**Re: Objection to MP08\_0244 MOD 1 Modification Request for Mixed Used Development at 23-37 Lindfield Avenue and 11 Havilah Lane, Lindfield**

1 SHADOW DIAGRAM - 21stDEC_9AM
5003 SCALE1 : 650

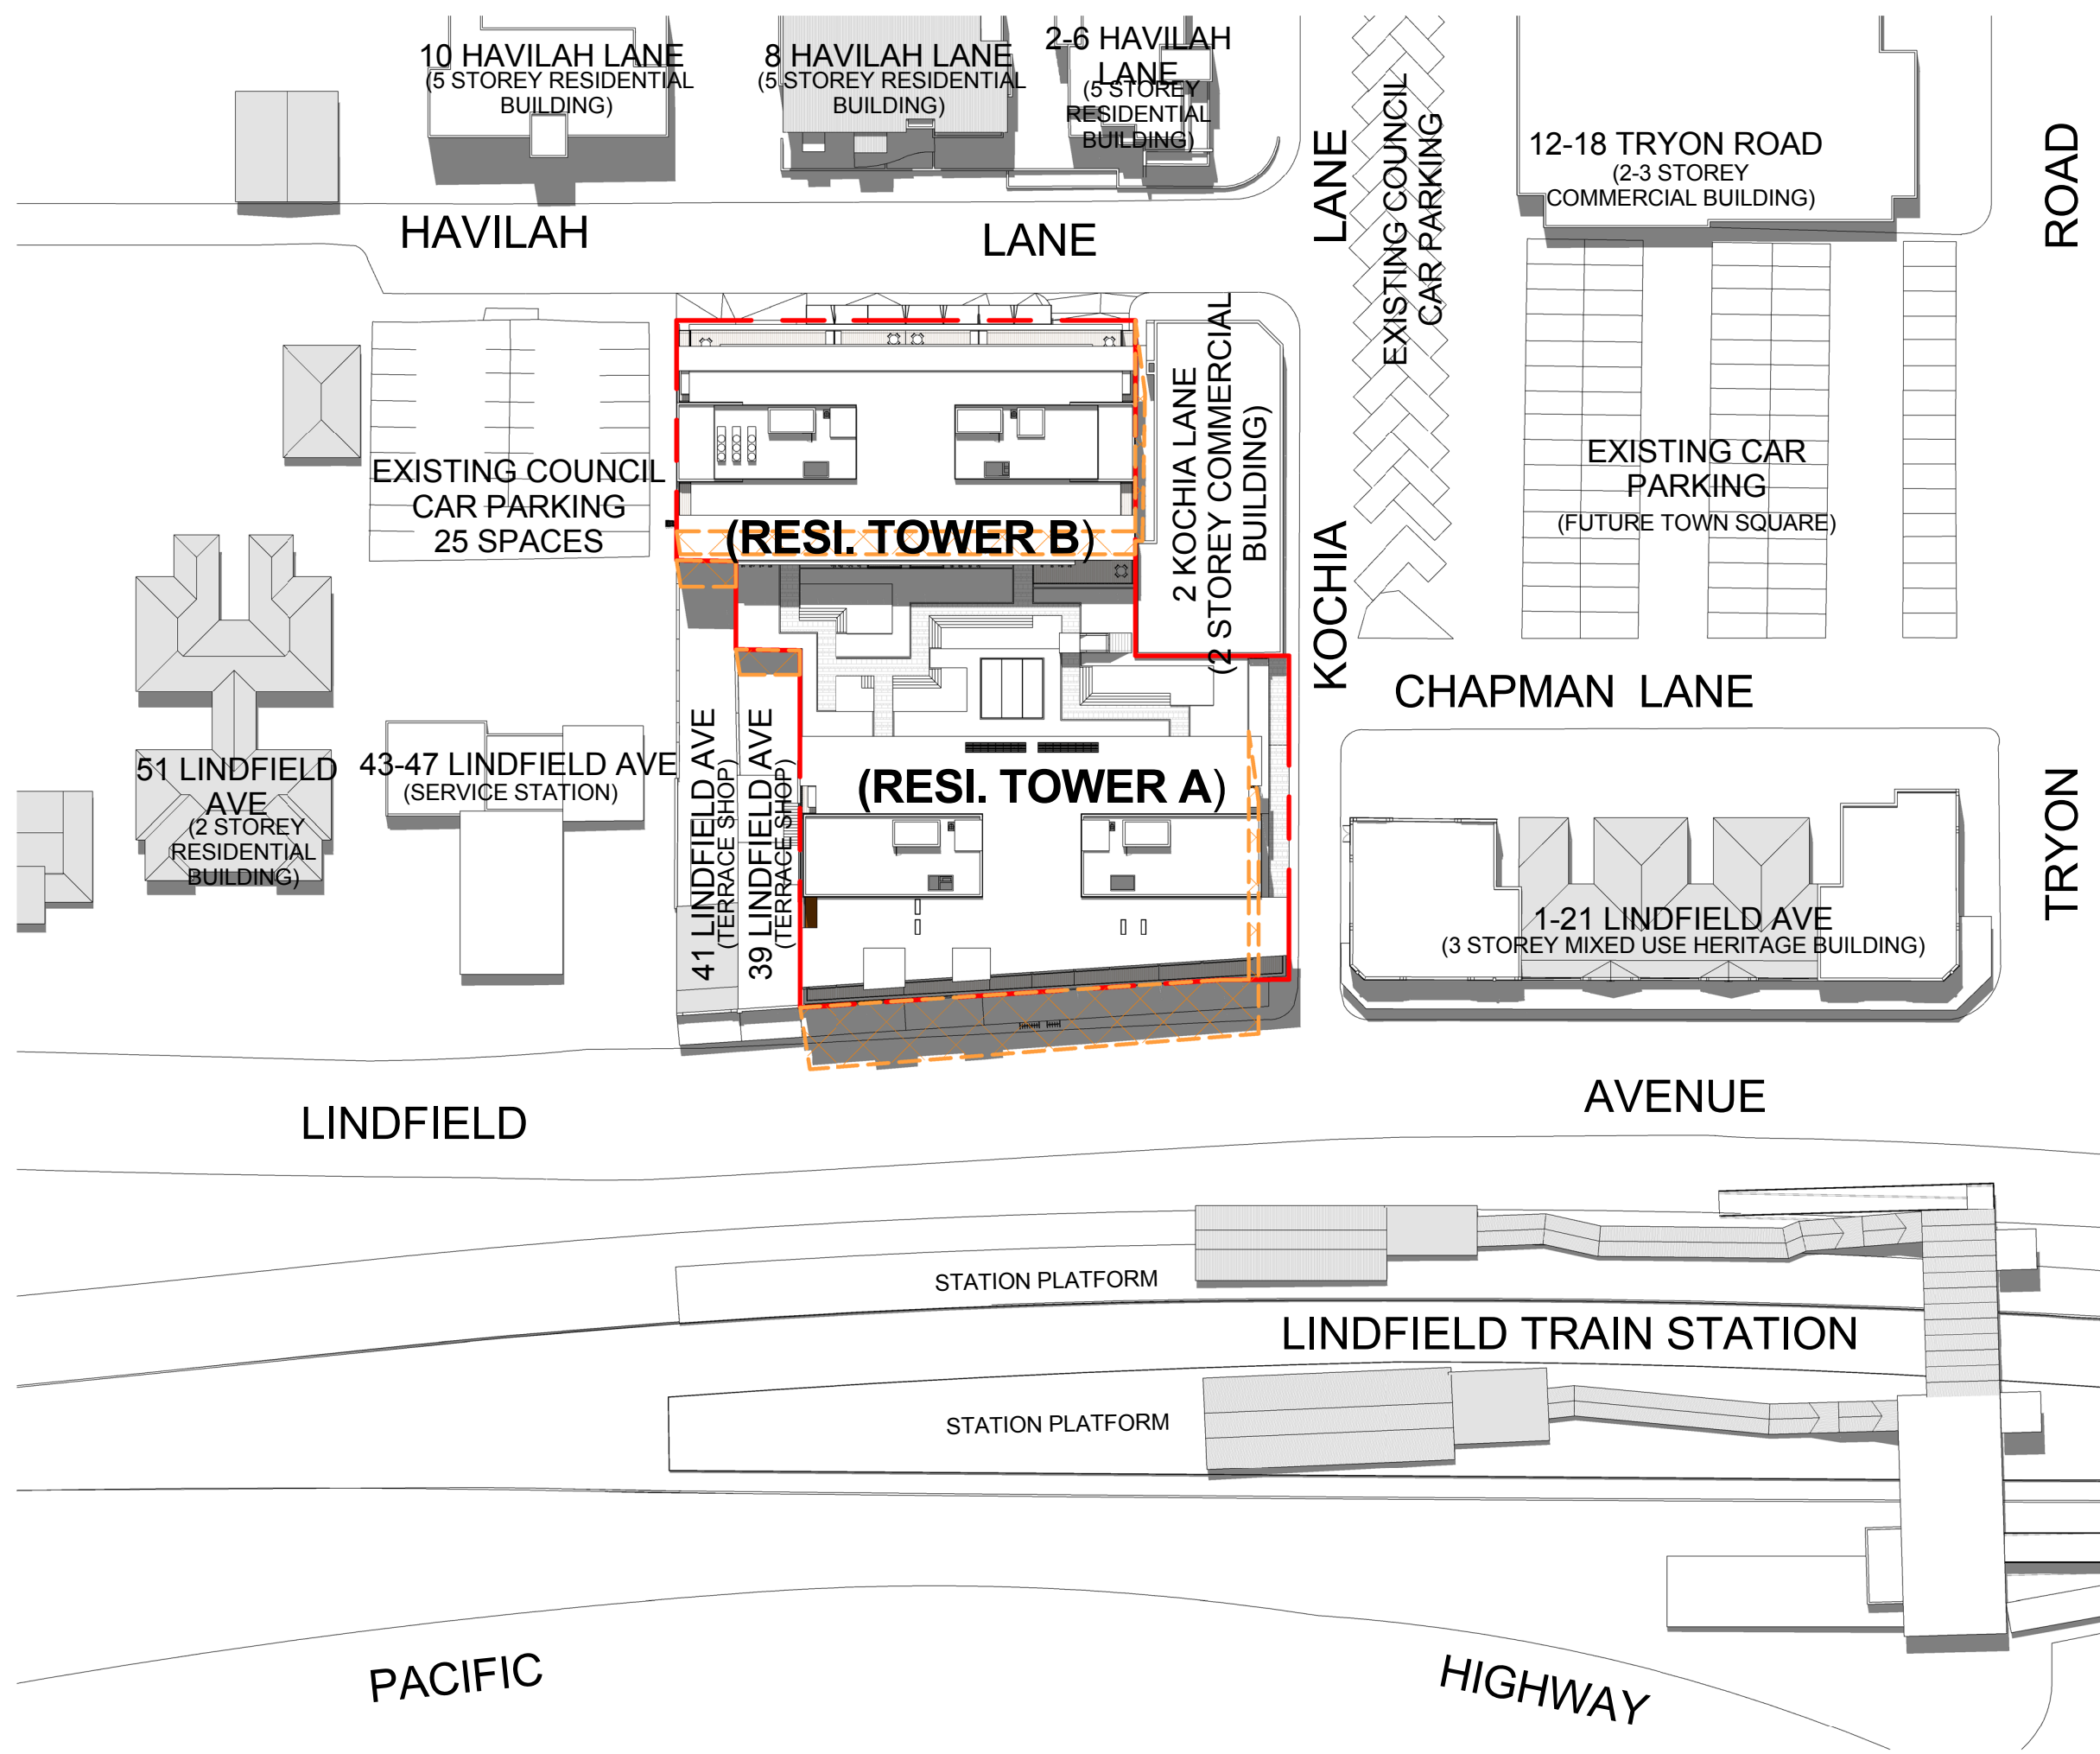
- The additional storeys create new adverse shadowing: a) for residents in the Havilah Lane apartments, particularly after 3pm b) for the popular outdoor café and central Lindfield hub area at 12 Tryon Road in afternoons, particularly in winter and c) for all commuters on the city bound Lindfield rail platform, instead of 50% of the year as approved, it will now be in shadow in the mornings 75% of the year
